**Re: Lexus of Albuquerque at 8421 Pan American Freeway
Erosion and Sediment Control Plan
Engineer's Stamp Date 2/21/2023 (F17E078)**

Based upon the information provided in your submittal received 2/22/2023, the above referenced ESC Plan cannot be approved until the following comments are addressed:

CONCRETE WASHOUT

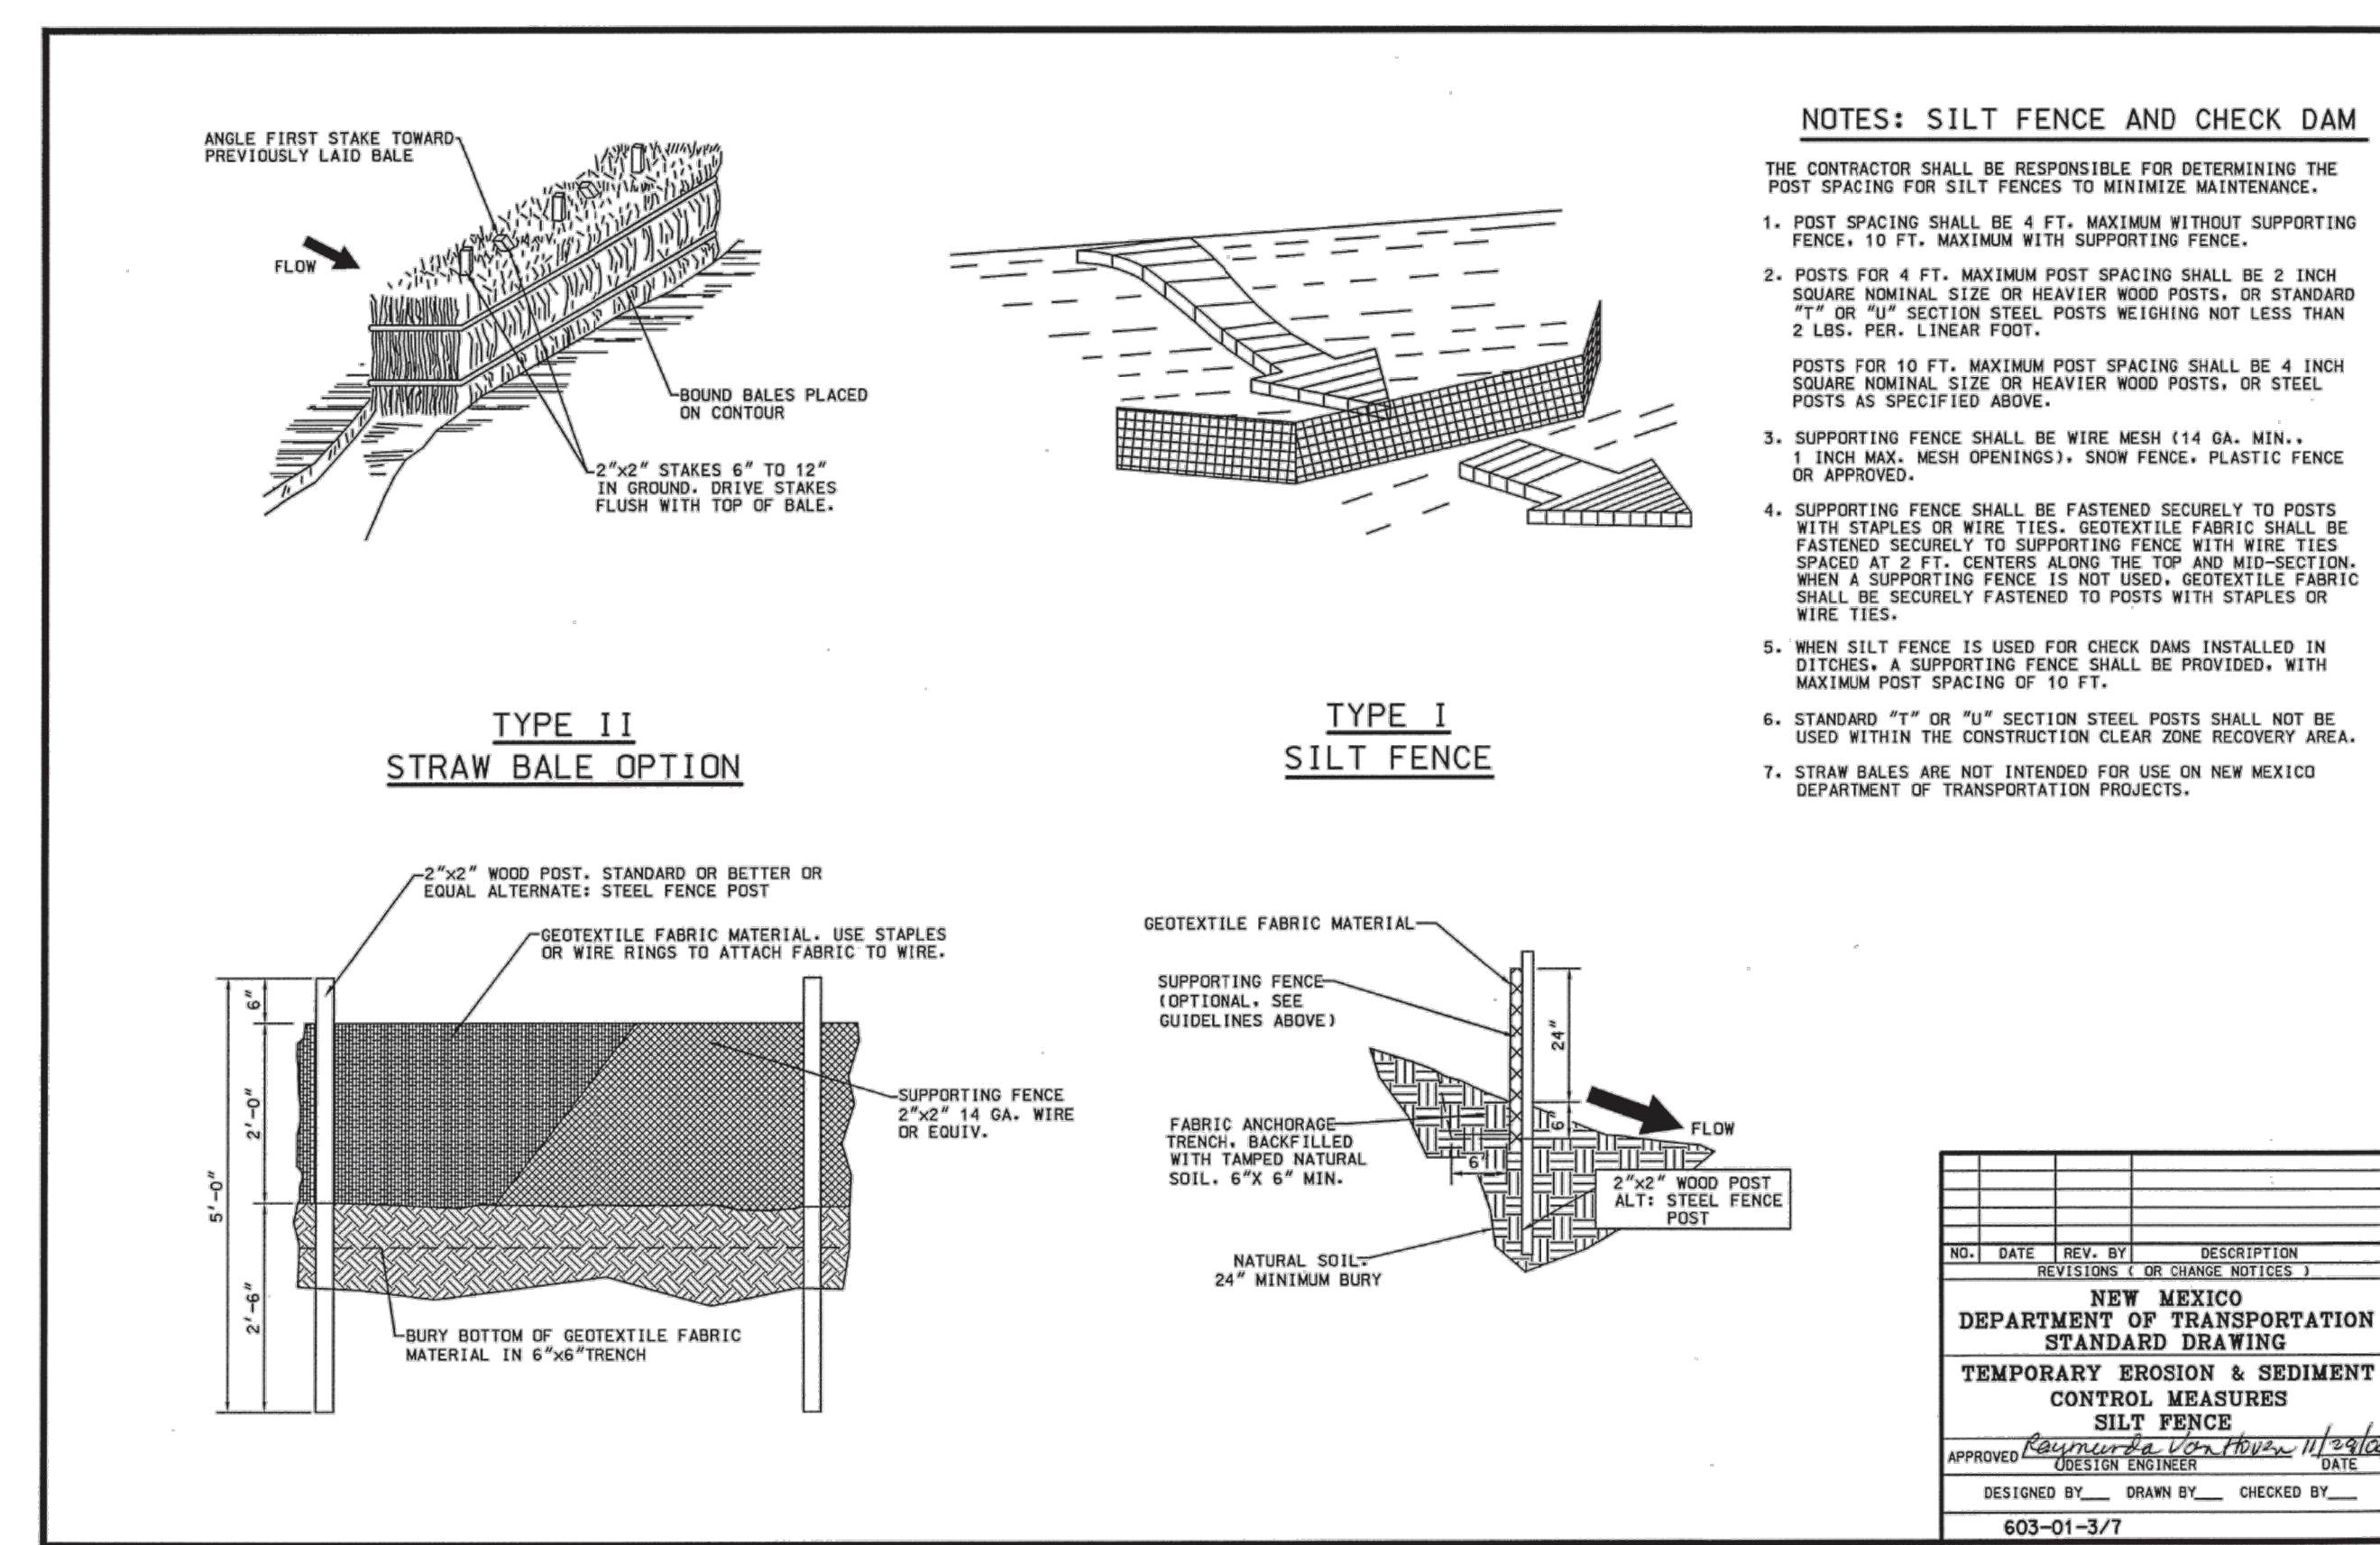
8. Erosion Control Note #10, talking about washout, should be deleted. "Direct wash water from concrete, paint, and stucco into a leak-proof container" per CGP 2.3.4. Identify the locations of the concrete washout.
Erosion Control Note #10 has been revised to state the above language.

C03.0

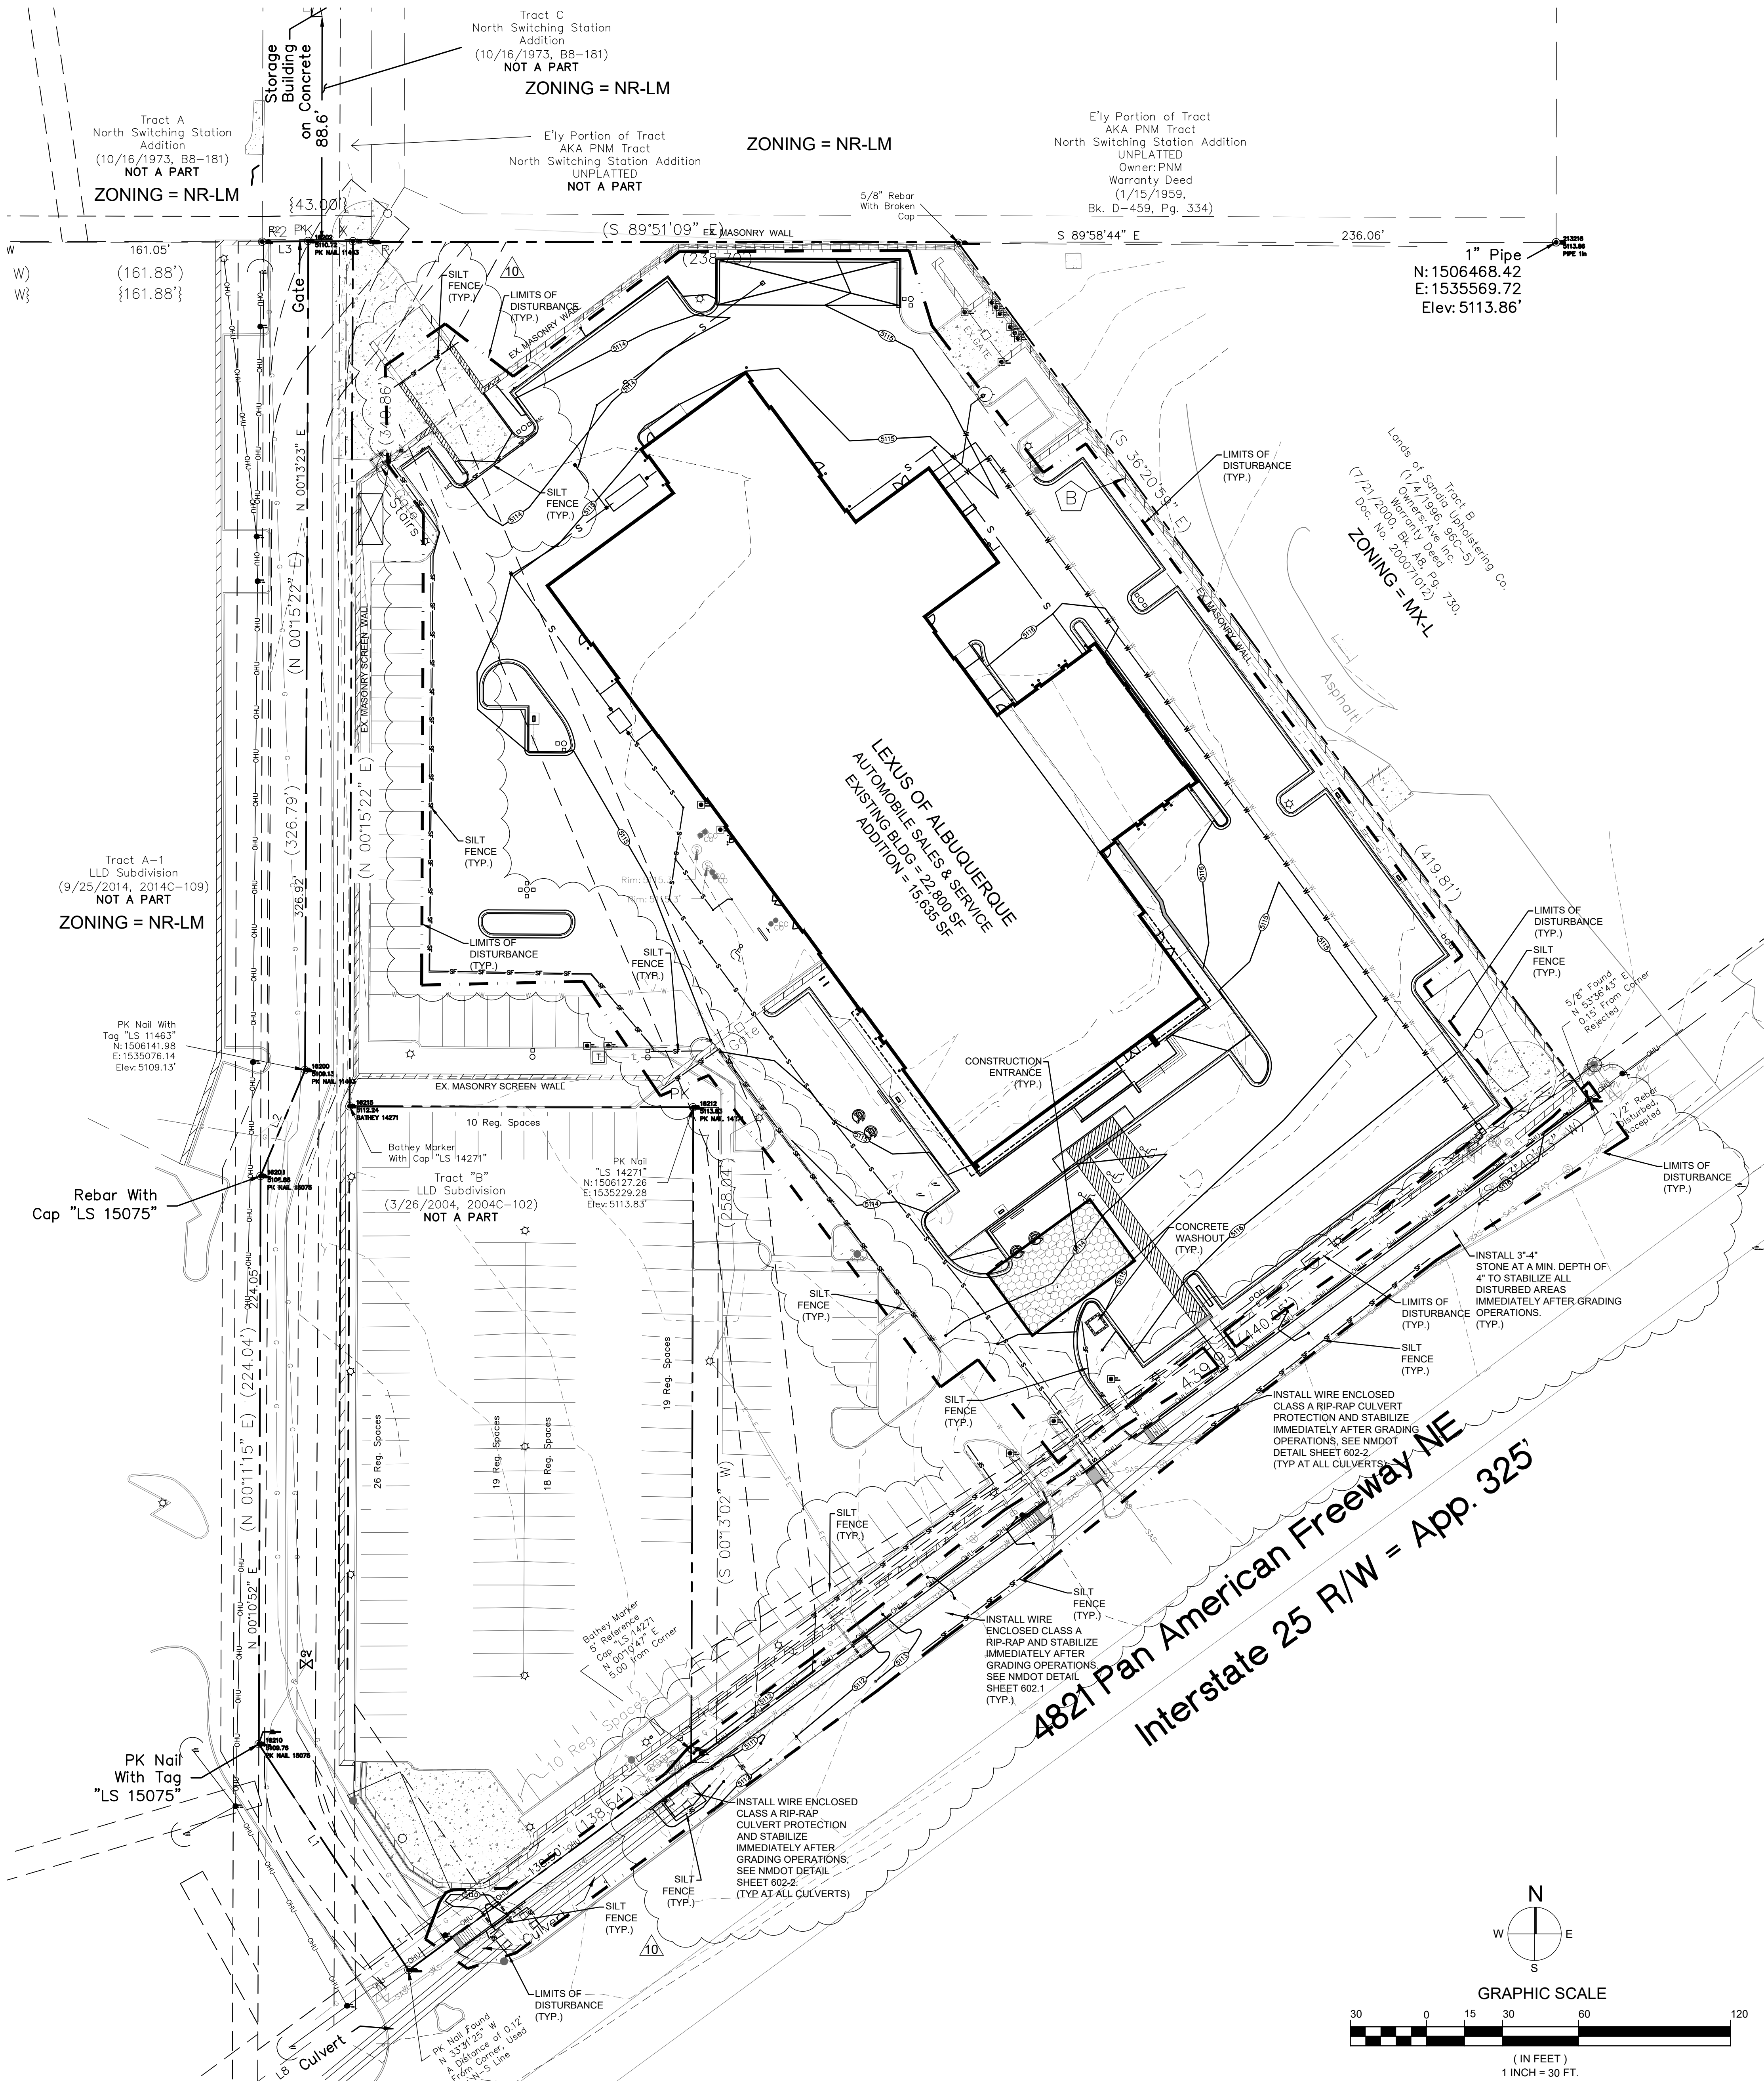
2. Identify locations of concentrated flow paths that enter and exit the disturbed areas. Identify locations where sheet flow enters and exits the disturbed area. Show on-site drainage patterns of stormwater before and after major grading activities. (CGP 7.2.4.f)
There are no concentrated flows that enter the disturbed areas. The site generally drains to the west and out of the site to a curb flume which drains to the R/W of Pan American Freeway.

3. This site is within 100 yards of the North Diversion channel which discharges to the Rio Grande. BMPs on site need to adhere more closely to the EPA's required controls in CGP 2.2 and the attached design guide for Silt Fences. Silt fence isn't appropriate for concentrated flows.
Plans revised to show additional silt fencing along the western boundary of the disturbed area and additional silt fence along the R/W curb flume. Also, additional silt fence has been added to the top of the existing ramp area along the northwest portion of the site. The front swale, conveyance area along the R/W will be immediately stabilized with larger stone and wire enclosed rip rap to address erosion control within this area.

4. Best Management Practices note #3 public notice must be revised to accurately state the posting requirements of CGP 1.5. "You must post a sign or other notice of your permit coverage at a safe, publicly accessible location in close proximity to the construction site. The notice must be located so it is visible from the public road that is nearest to the active part of the construction site, and it must use a font large enough to be readily viewed from a public right-of-way."
Best Management Practices note #3 has been revised to state the above language.

5. Best Management Practices note #4, please add that the SWPPP must be kept up-to-date per CGP 7.1.
Best Management Practices note #4 revised to add above language and added this statement, "The location of the limits of disturbance and the corresponding BMPs needs to be planned ahead of time and shown accurately on the SWPPP maps for each phase. The staging area should be included inside the silt fence during each phase."

5. Best Management Practices note #14 conflicts with Erosion Control Note #10 regarding the frequency of inspections (14 days is acceptable) and both are wrong regarding the depth of rain that triggers the need for additional inspection (0.5" should be 0.25").
Best Management Practices note #14 and EC Note #3 revised to show 14 day frequency of inspection and depth of rain that the need for additional inspection is revised to .25".

7. Erosion Control Note #6 should say "Where sediment has been tracked-out from your site onto paved roads and sidewalks remove the deposited sediment by the end of the same business day" CGP 2.2.4.d.
Erosion Control Note #6 has been revised to state the above language.
